GRADING AND EROSION CONTROL PLAN CHECKLIST

Creekside South at Lorson Ranch Fil. No. 1

STORMWATER MANAGEMENT PLAN CHECKLIST

**CREEKSIDE SOUTH AT LORSON RANCH
 OVERLOT EARLY GRADING AND
 EROSION CONTROL PLAN**

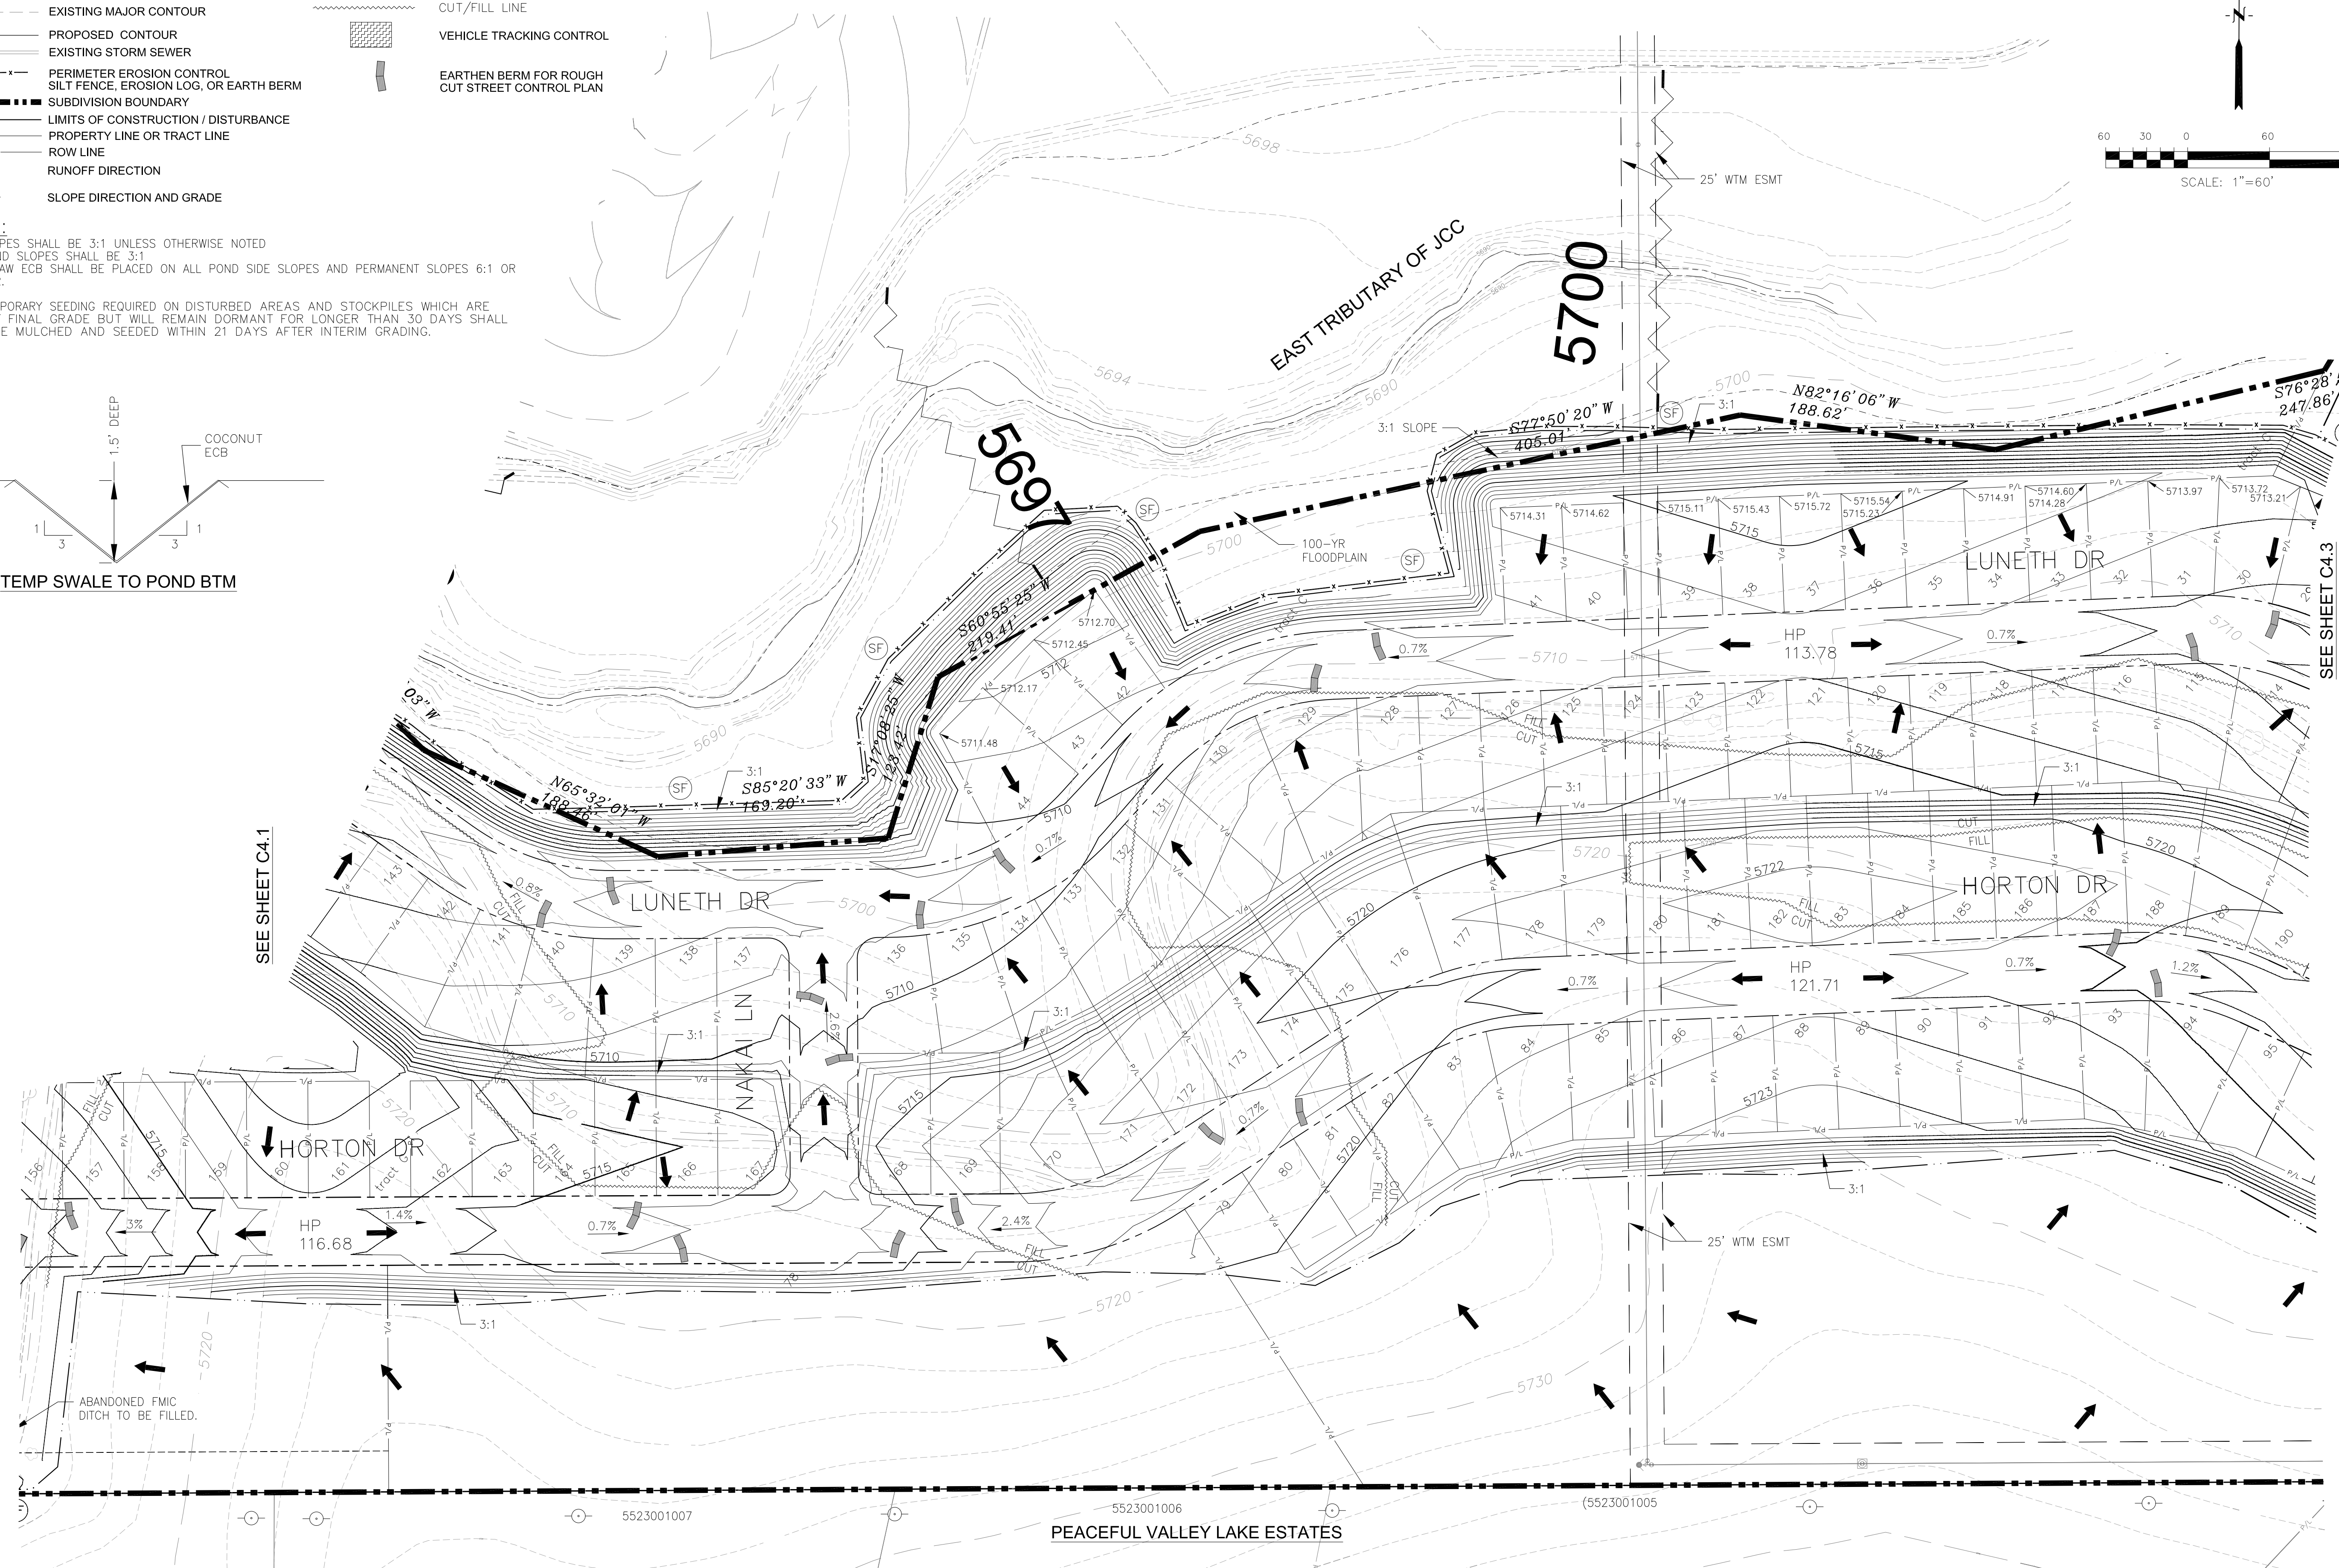
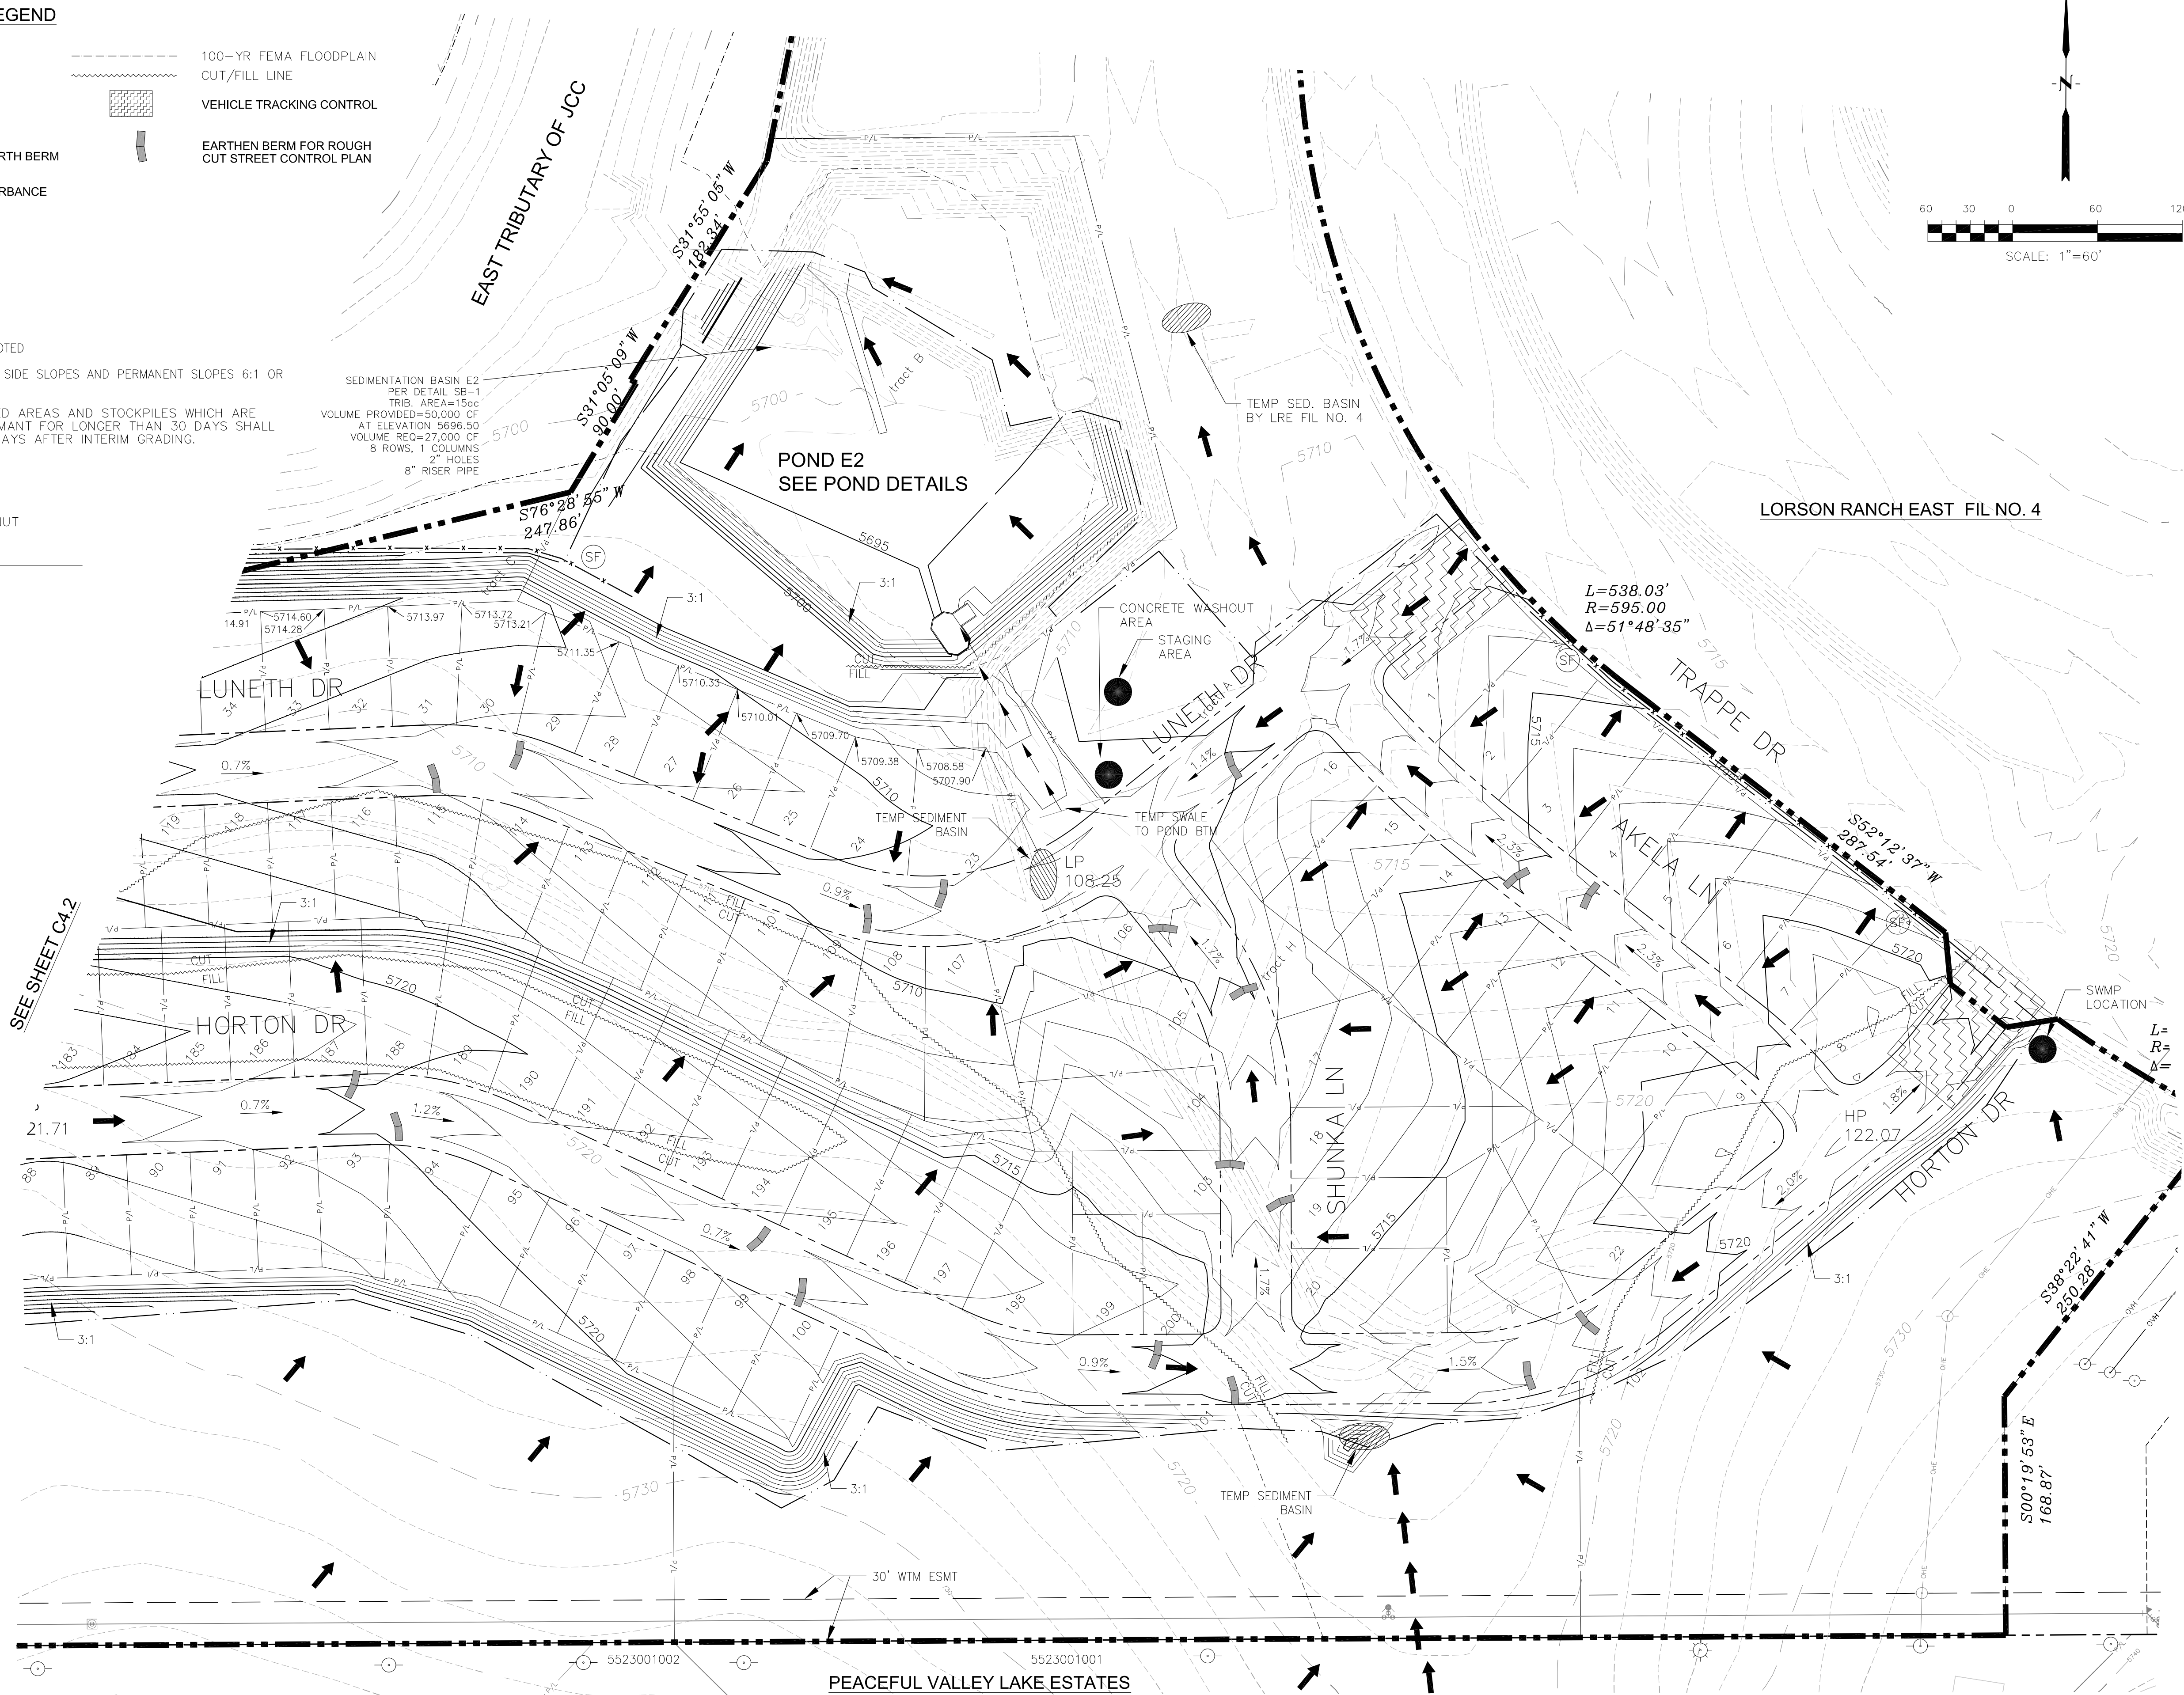
Applicant	PCD
1. GRADING AND EROSION CONTROL PLAN			
a	Vicinity map.	y	✓
b	Adjacent city/town/jurisdictional boundaries, subdivision names, and property parcel numbers labeled.	y	✓
c	North arrow and acceptable scale (1"=20' to 1"=100').	y	✓
d	Legend for all symbols used in the plan. Show ECB	y	✗
e	Existing and proposed property lines. Proposed subdivision boundary for subdivision projects.	y	✓
f	All existing structures.	y	✓
g	All existing utilities.	y	✓
h	Construction site boundaries.	y	✓
i	Existing vegetation (notes are acceptable in cases where there is no notable vegetation, only grasses/weeds, or site has already been stripped).	y	✓
j	FEMA 100-yr floodplain.	y	✓
k	Existing and proposed water courses including springs, streams, wetlands, detention ponds, stormwater quality structures, roadside ditches, irrigation ditches and other water surfaces. Show maintenance of pre-existing vegetation within 50 feet of a receiving water.	y	✓
